# Comment for planning application 22/00499/DISC

Application Number	22/00499/DISC
Location	The Stables Main Street Great Bourton Cropredy OX17 1QU
Proposal	Discharge of condition 5 (Site Development Scheme) of 20/02060/F (Appeal ref APP/C3105/C/21/3268454)
Case Officer	Wayne Campbell
Organisation	
Name	Clerk to the Council
Address	Bourtons Community Hall, Main Street, Great Bourton, Banbury, OX17 1QU
Type of Comment	Comment
Type	neighbour
Comments	See attached
Received Date	17/03/2022 14:26:32
Attachments	The following files have been uploaded: <ul style="list-style-type: none"><li>22.00499.DISC response.docx.pdf</li></ul>

Dear Sirs  
Response to Application Consultation  
Discharge of condition 5 (Site Development Scheme) of 20/02060/F (Appeal ref  
APP/C3105/C/21/3268454 : The Stables, Main Street, Great Bourton

# SITE LAYOUT PLAN

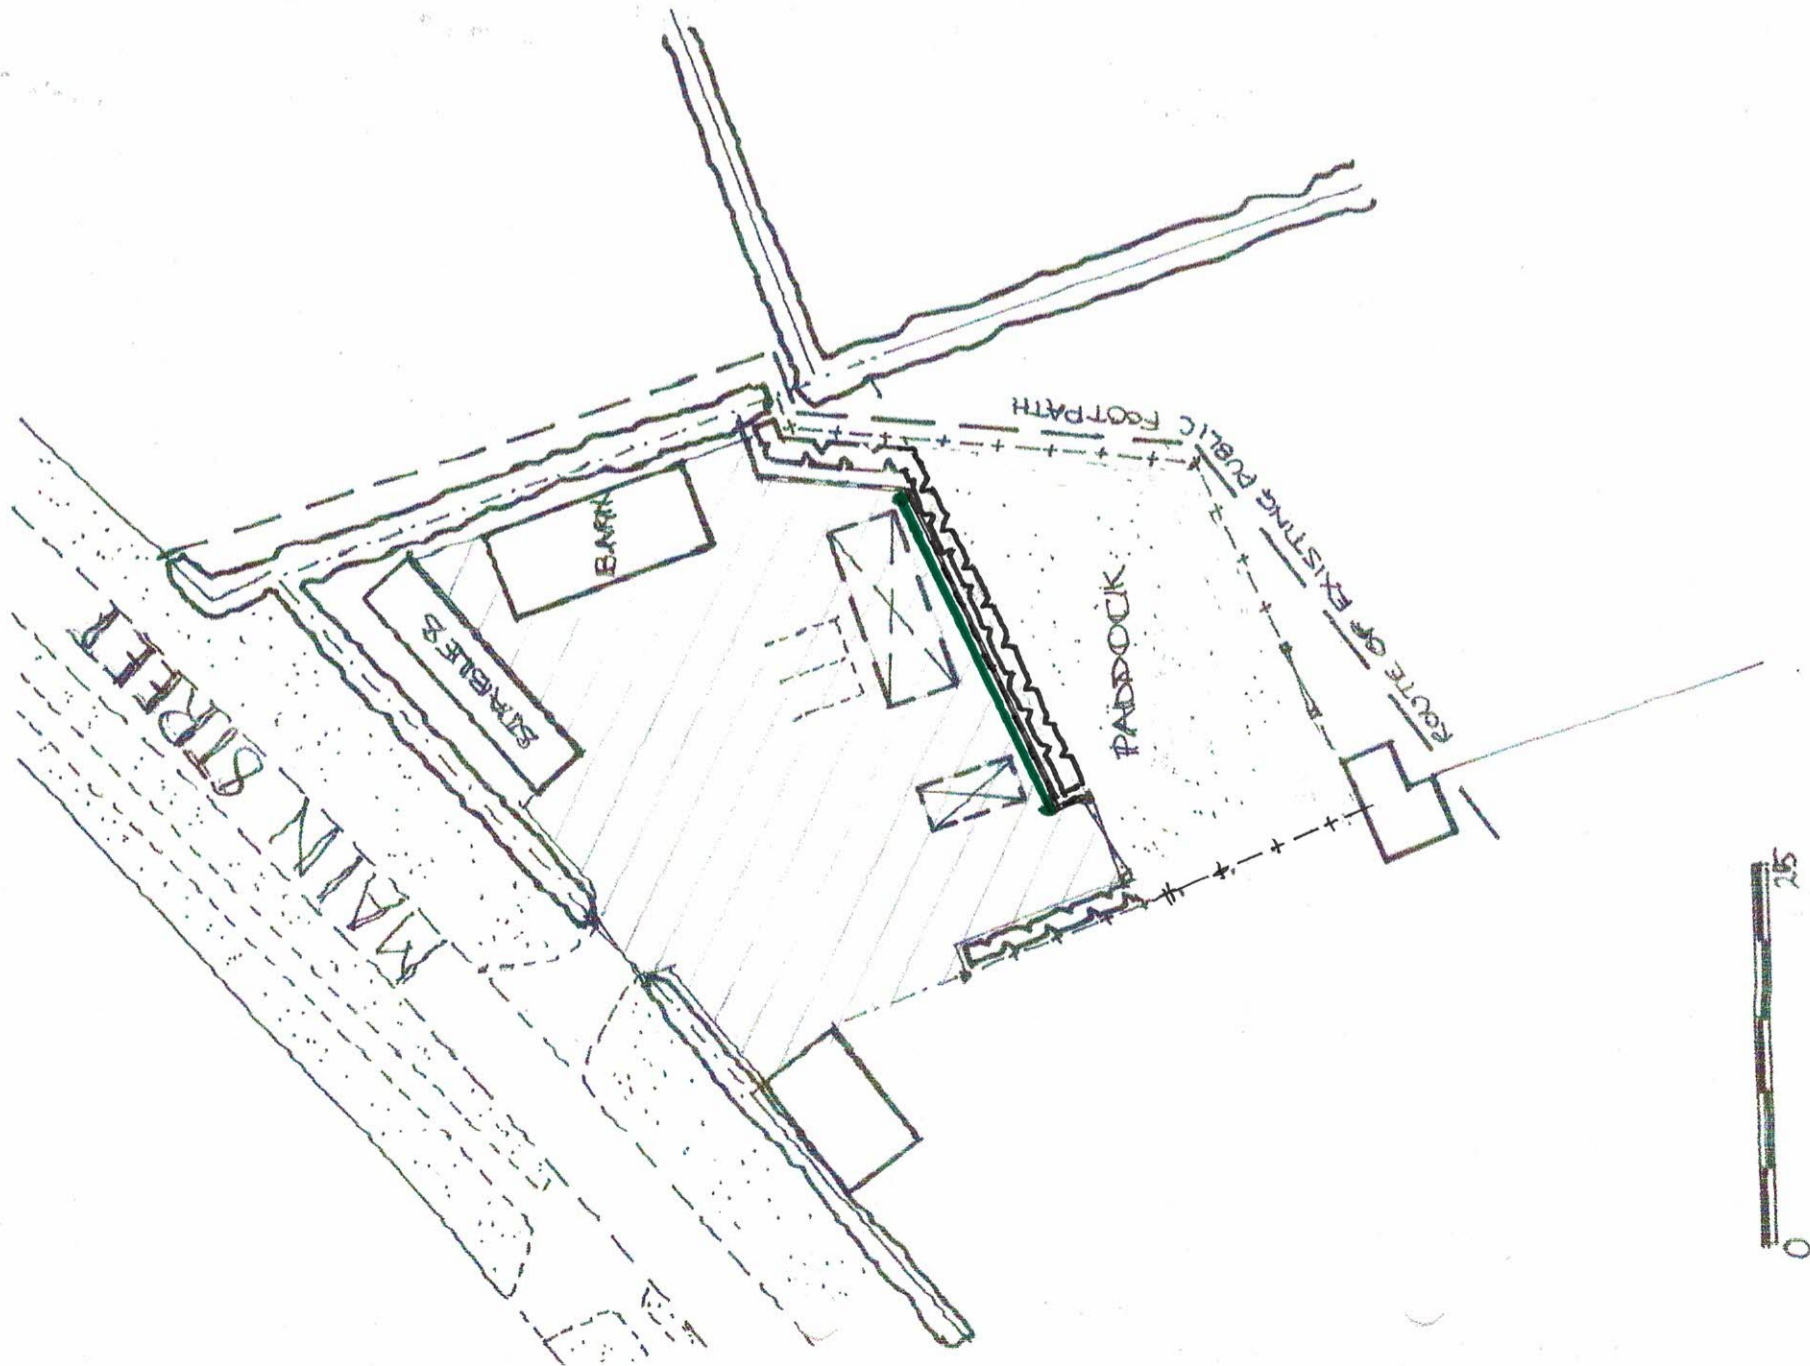
1. The site at the time of the application already had an area of hardstanding on the northern boundary on which was sited an occupied touring caravan. The appellant confirmed at the hearing "that this hardstanding area was intended to be the siting position of the caravans". We therefore question why there is a need for a large extension to the hardstanding, which has already been constructed using rubble imported from another location.

We would suggest that the very significant quantity of rubble that has been added to extend the existing hardstanding will create a serious flood risk, and indeed surface water flooding of the adjacent field next to the railway line has already been observed. Although the area is identified as being located in Flood Risk area 1, the Environment Agency, OCC Education Department and CDC are all fully aware of the regular flood problems this area experiences.

We therefore request that such a condition as suggested by the Inspector be imposed and that action be taken to either remove the additional hardstanding, or further measures to minimise the increased flood risk. This is essential if flooding and all of its associated inconvenience

3. The Inspector also specifies that screening tree planting should be undertaken and the appellant’s agent in his covering letter states that the species to be planted will be hawthorn, blackthorn and holly. However, just after the site was purchased the appellant installed new boundary fencing and planted leylandii and laurel trees along the new fence on both this site the adjacent Paddocks site. The laurel and Leylandii should be removed and the required planting schedule implemented as soon as possible. We would also point out that laurel trees are poisonous to horses and that horses are grazed in the field at the rear of The Stables site, also owned by the appellant and in land adjoining The Paddocks. This can cause serious health and welfare issues to horses so the laurel trees should be removed to protect the animals.
